CD_V4_Comments.pdf Markup Summary

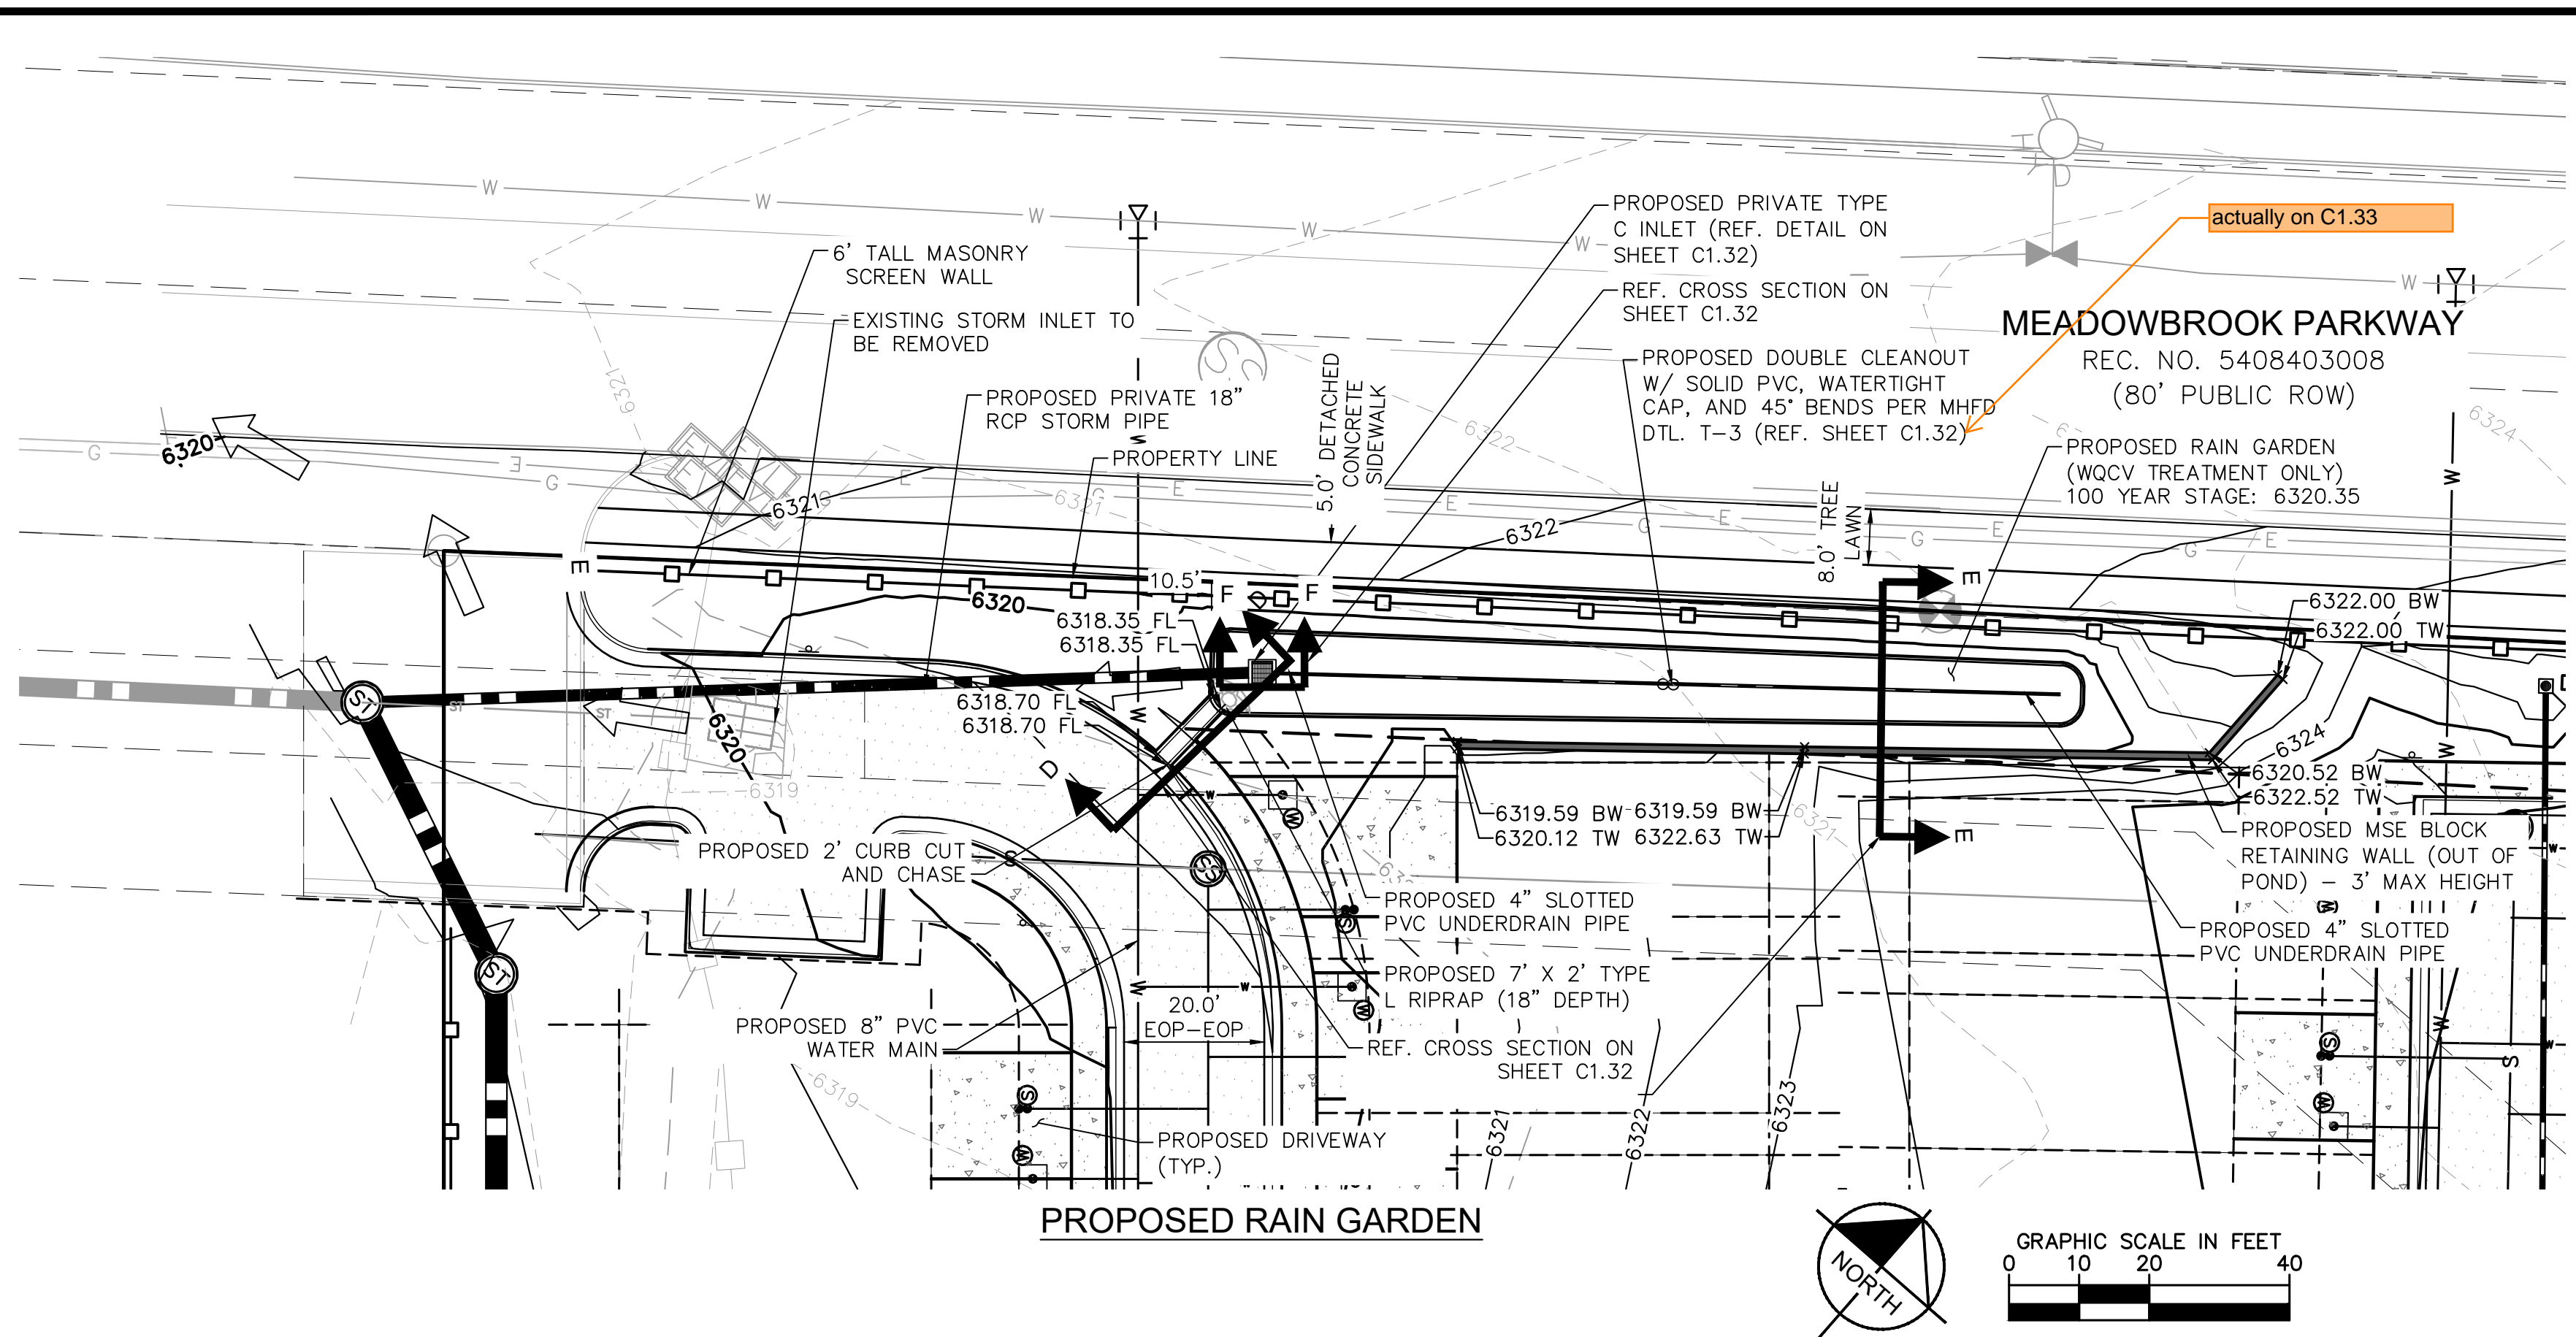
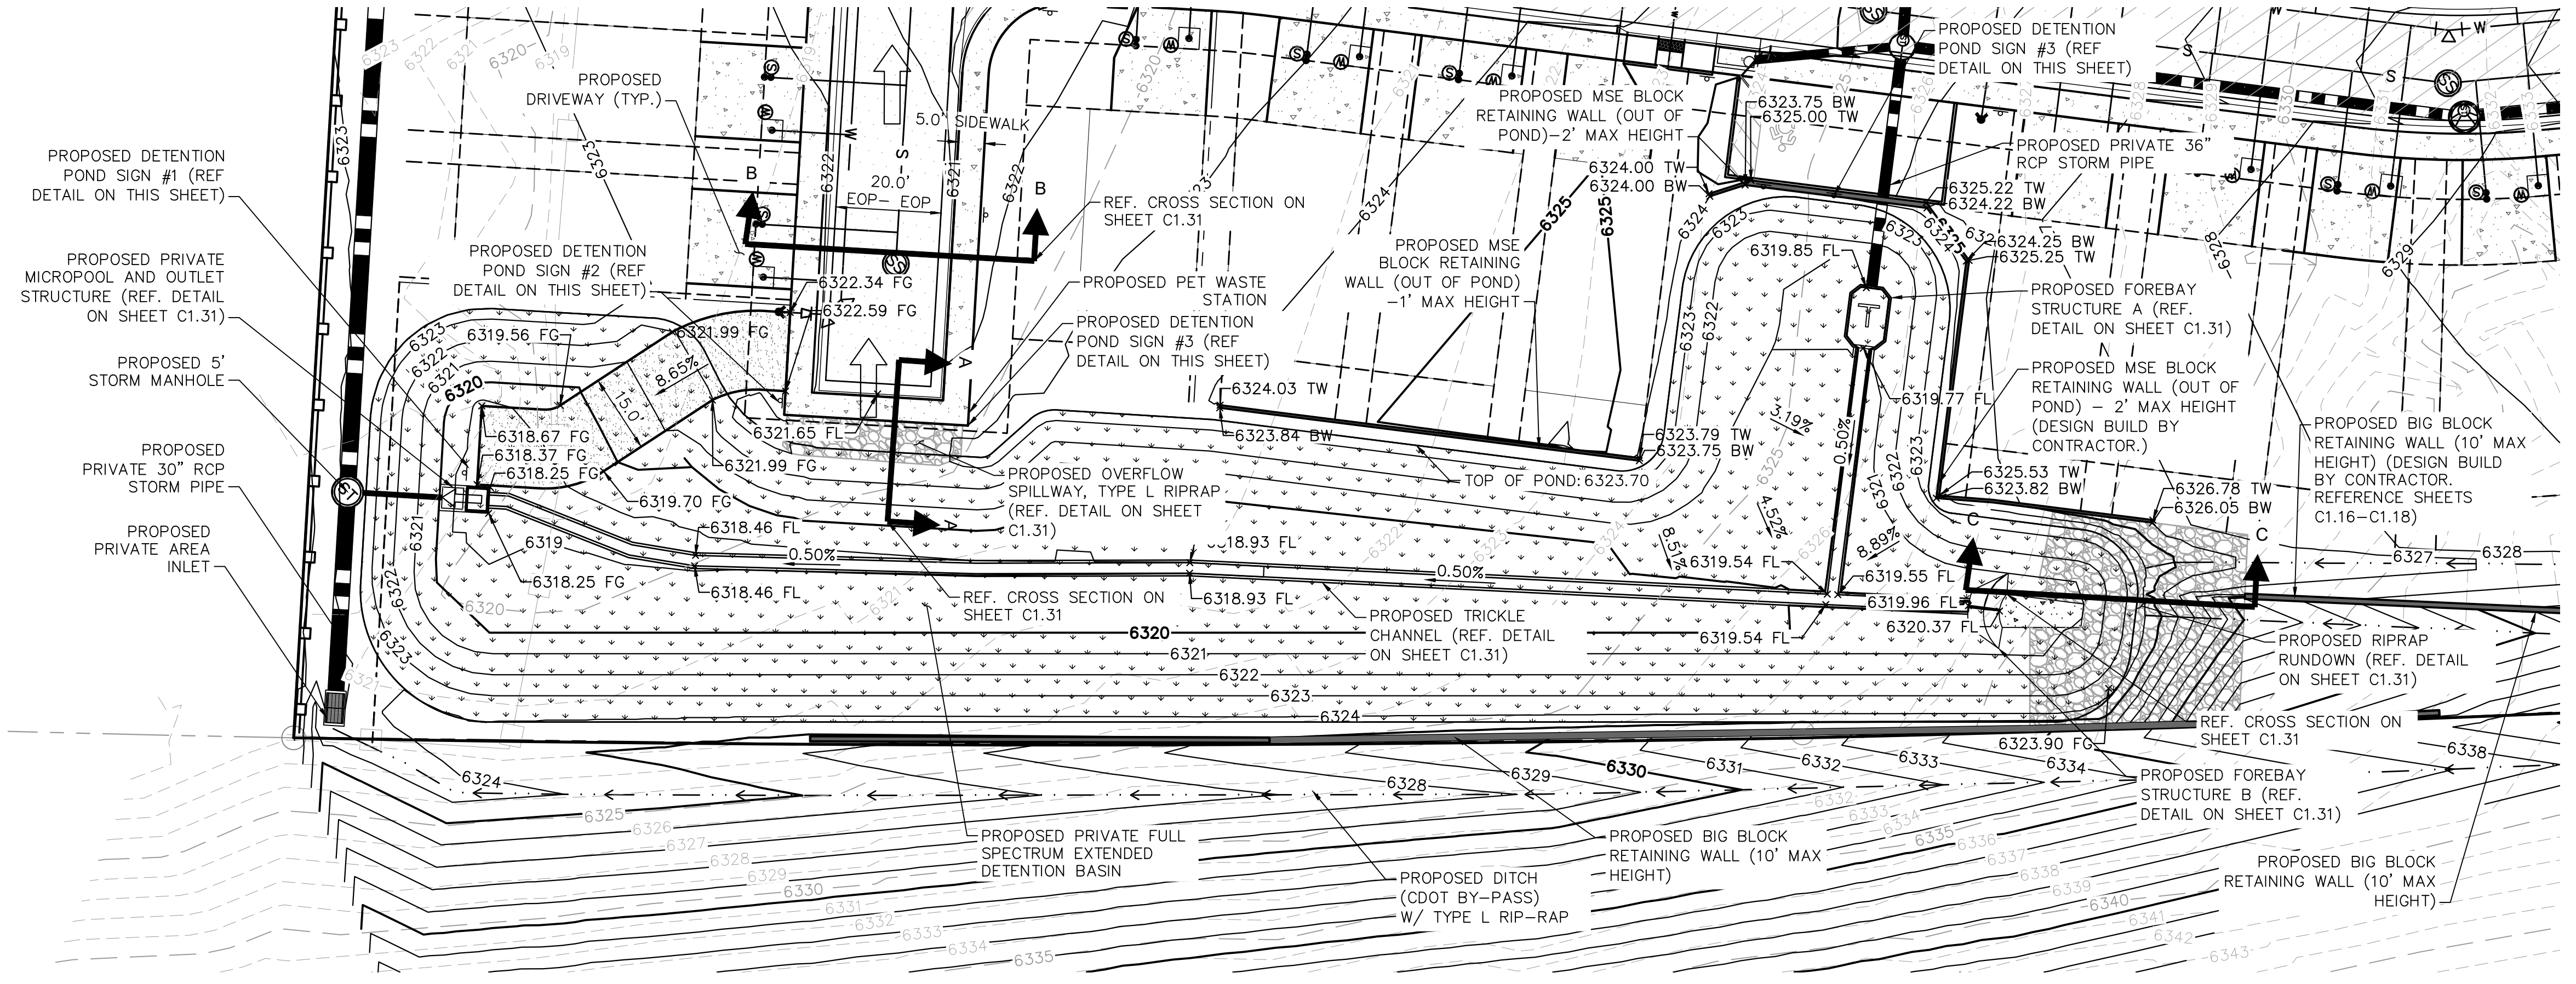
Per the MHFD detention calculation it appears that the EURV WSE is 6322.23 but the top of the overflow weir is 6321.60. Please revise accordingly.

URV WSE: 6321.60

RV WSE: 6321.44
CV WSE: 6320.18
